# ***City of Albuquerque***

**RE: WELLS FARGO BANK REMODEL @ MONTGOMERY AND WYOMING NE  
(F19-D13B). DRAINAGE REPORT AND GRADING & DRAINAGE PLAN FOR  
BUILDING PERMIT AND SO#19 PERMIT APPROVALS. ENGINEER'S STAMP  
DATED NOVEMBER 7, 2001.**

Dear Mr.Green:

11-07-2001  
 SHEET DR1 of 2

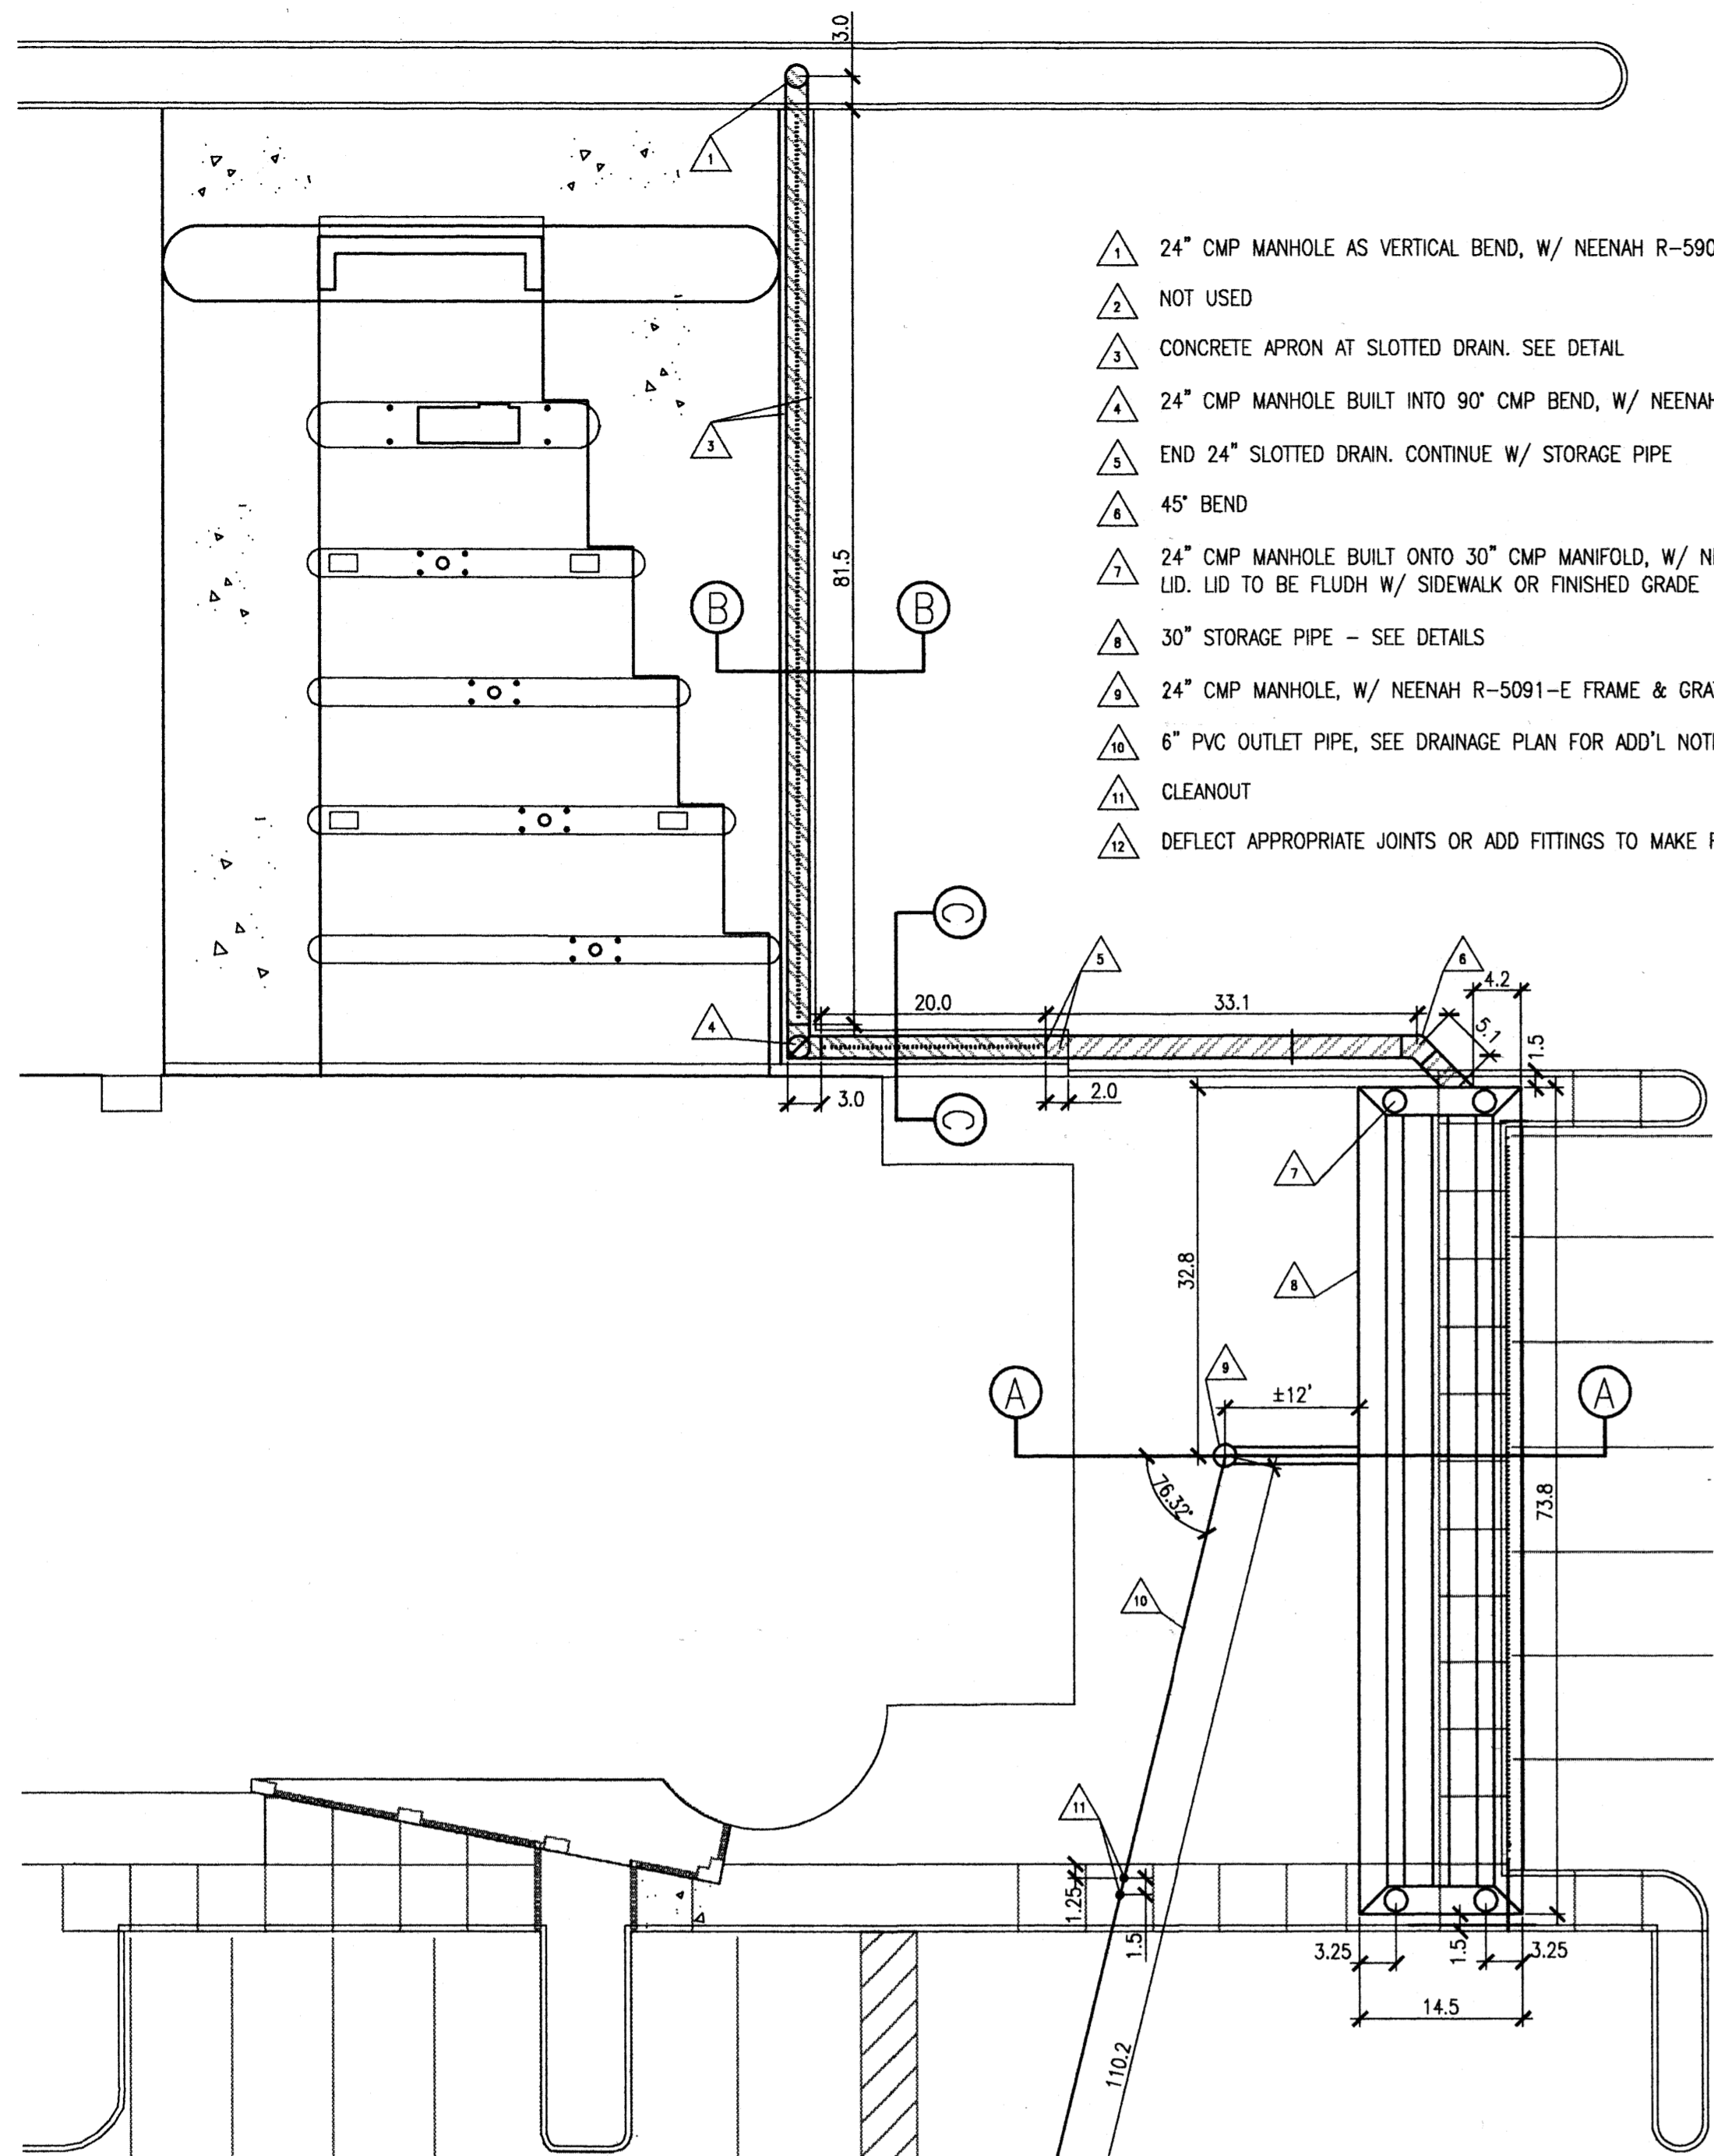
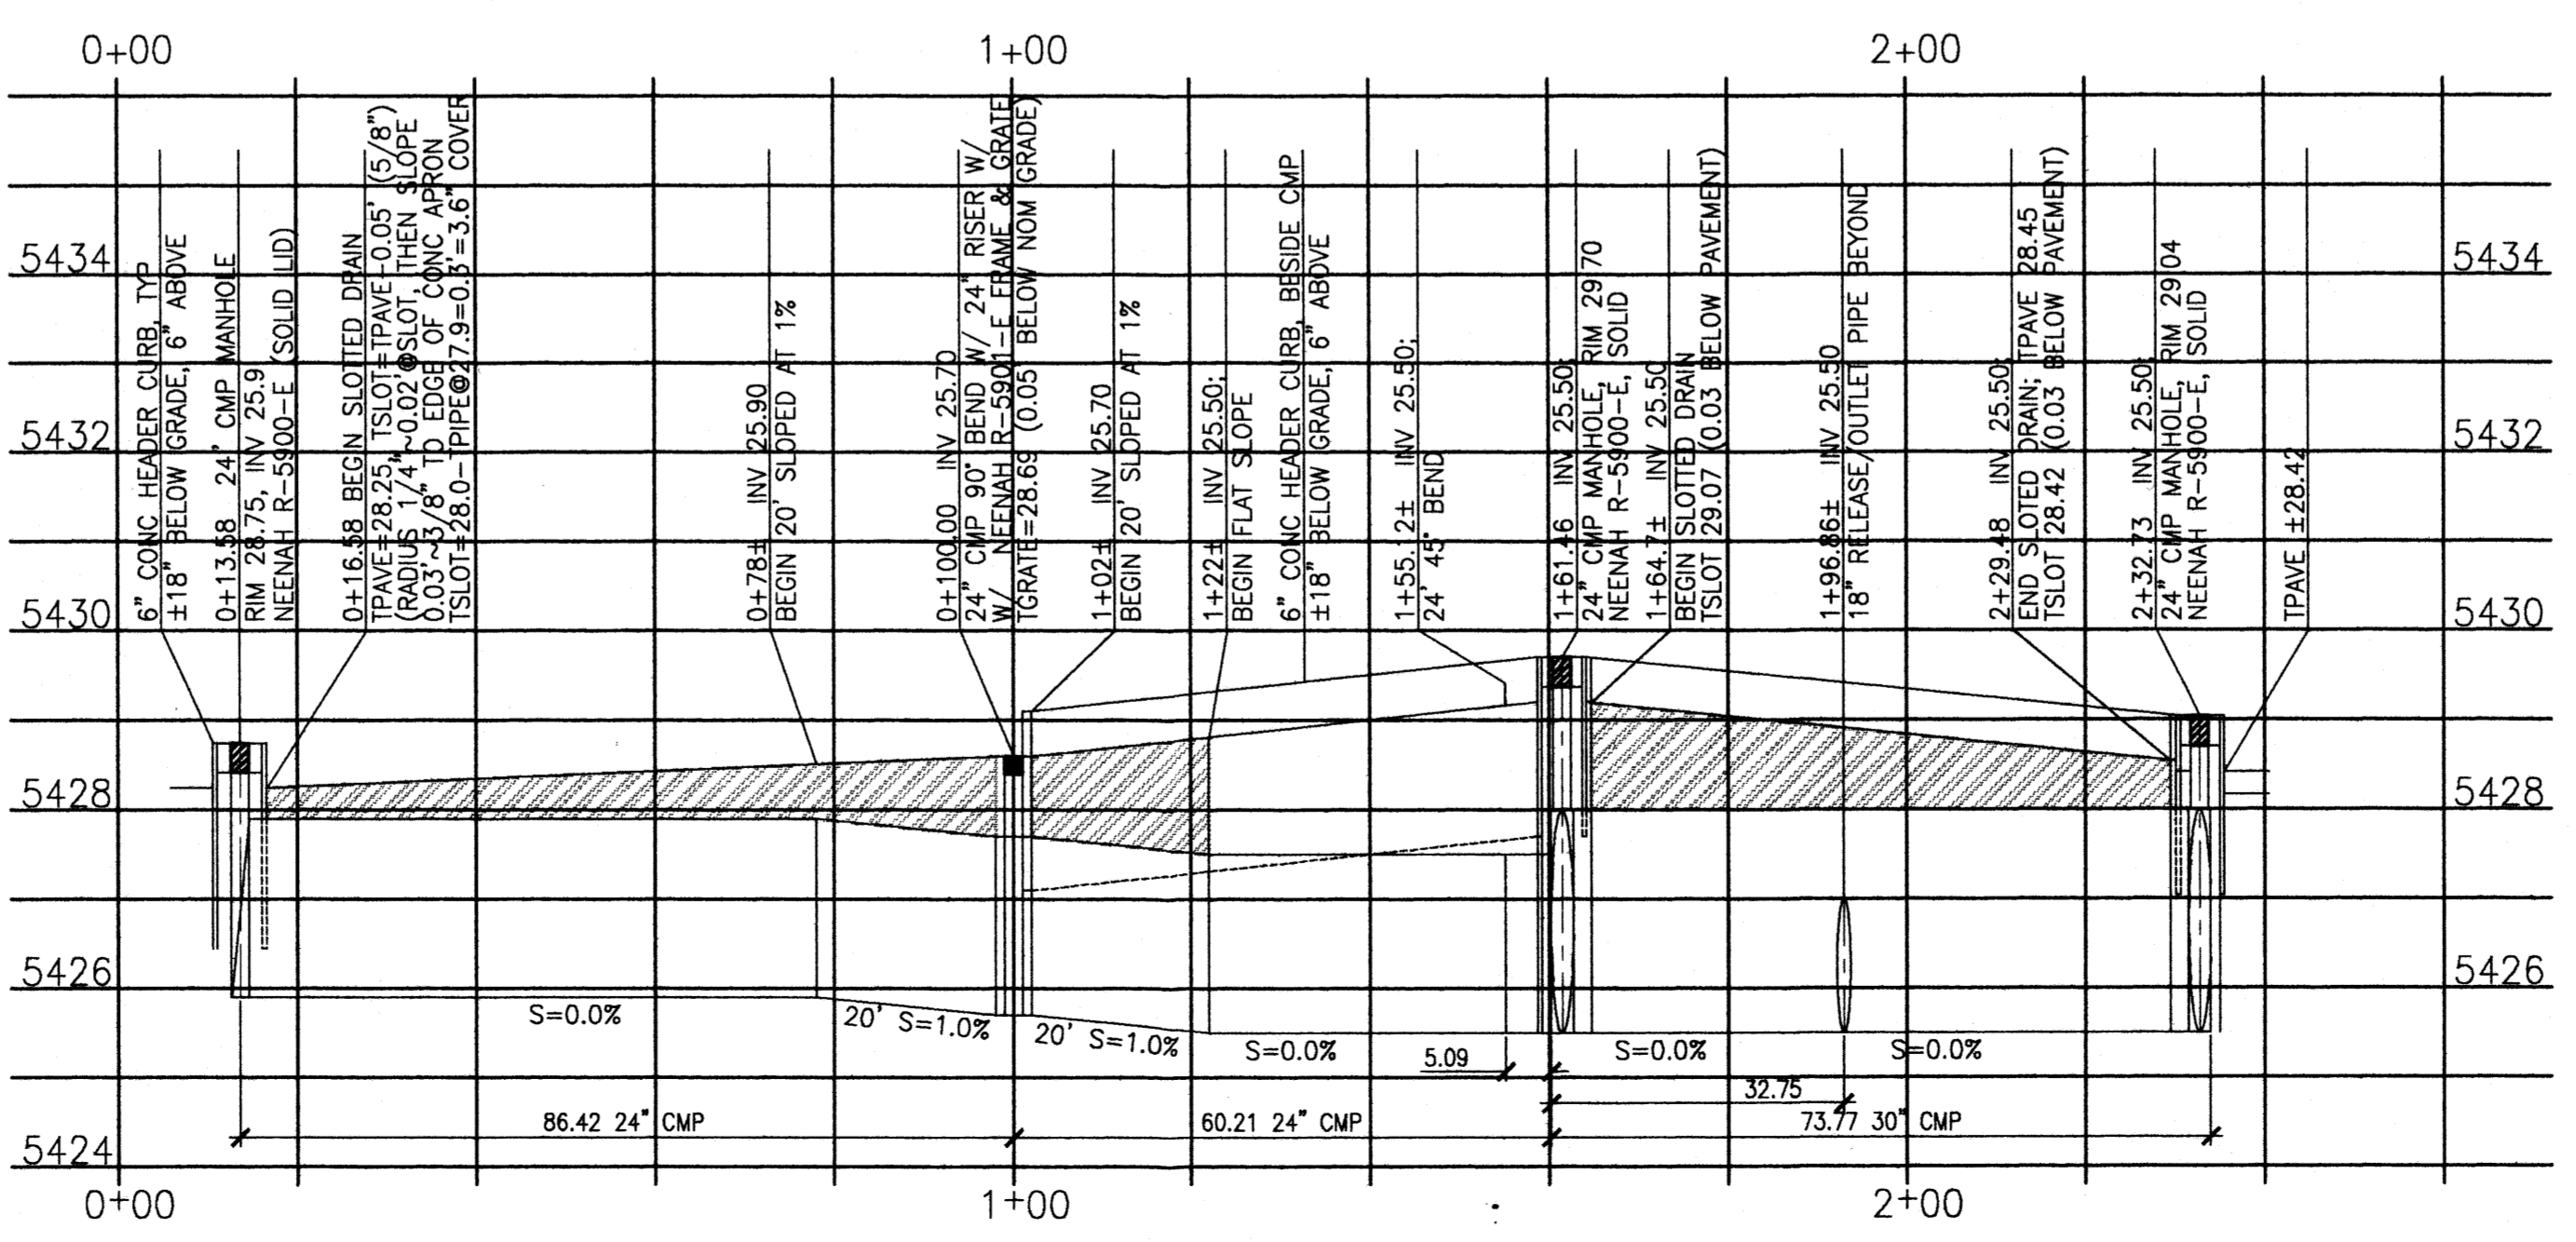
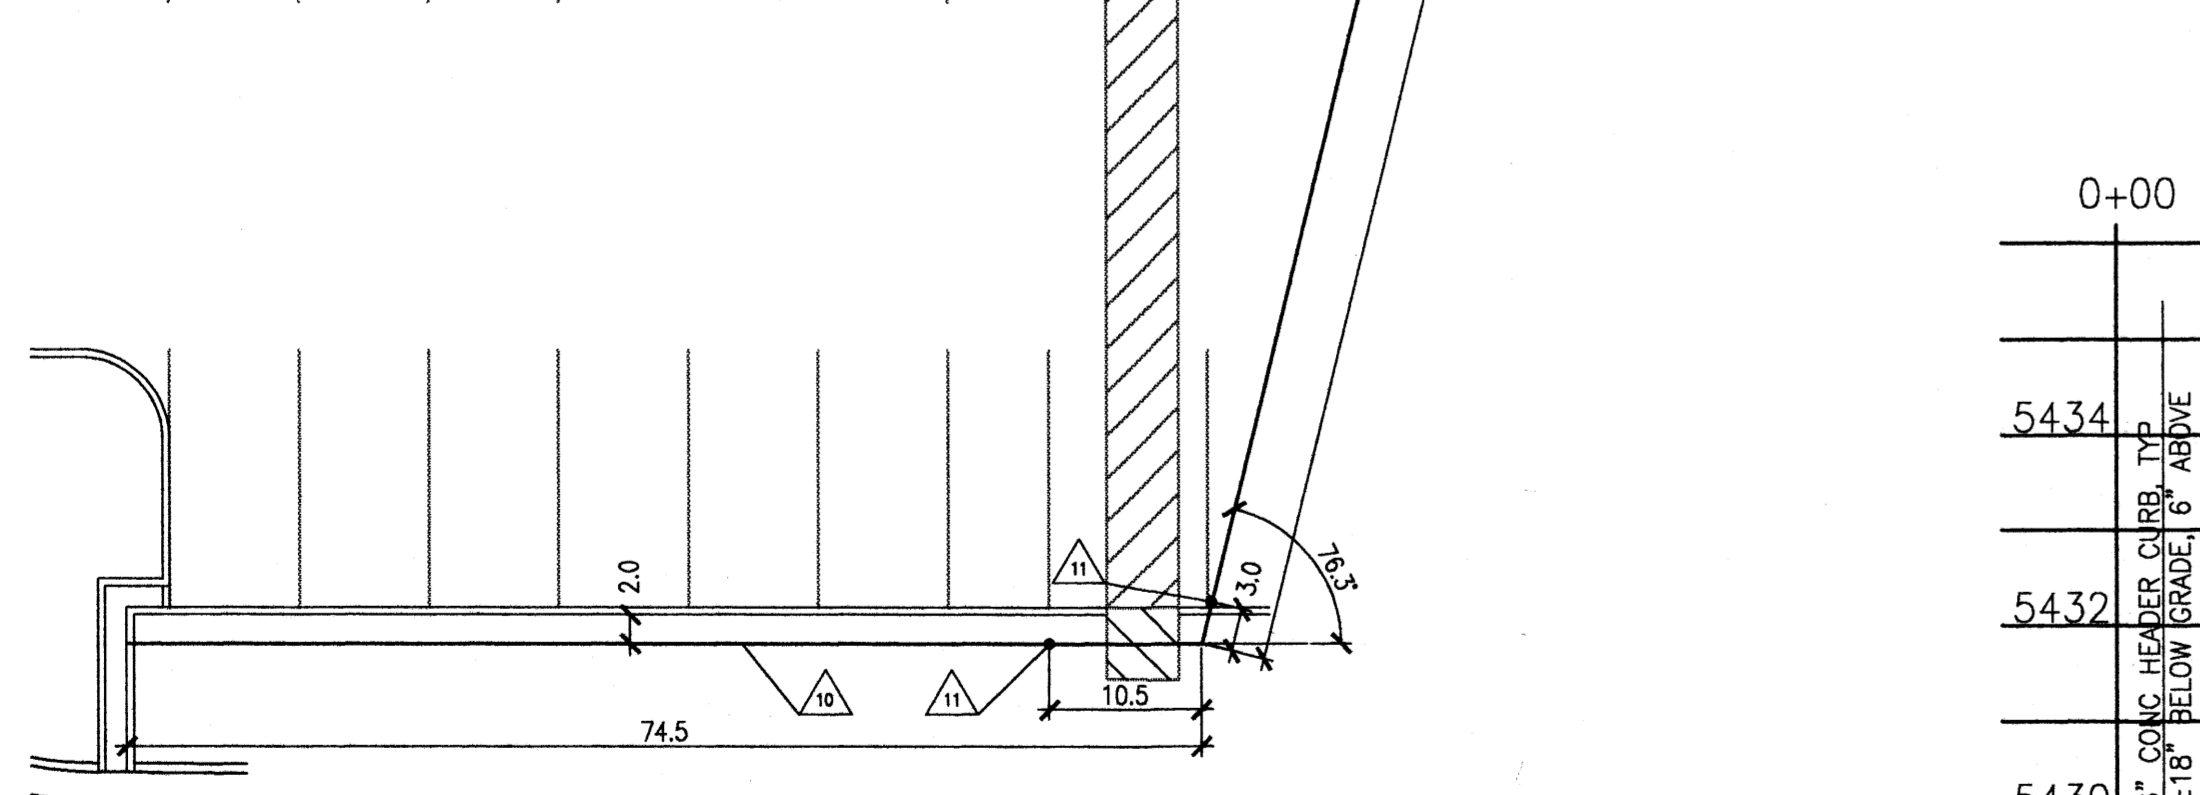
\*\*\*It is unclear where the north property line is located. Please show on the plan and complete any necessary plat action. The report notes a 25-foot strip was added on the north side. Is the limit of grading within that addition? If not, permission will be required from abutting site owner.
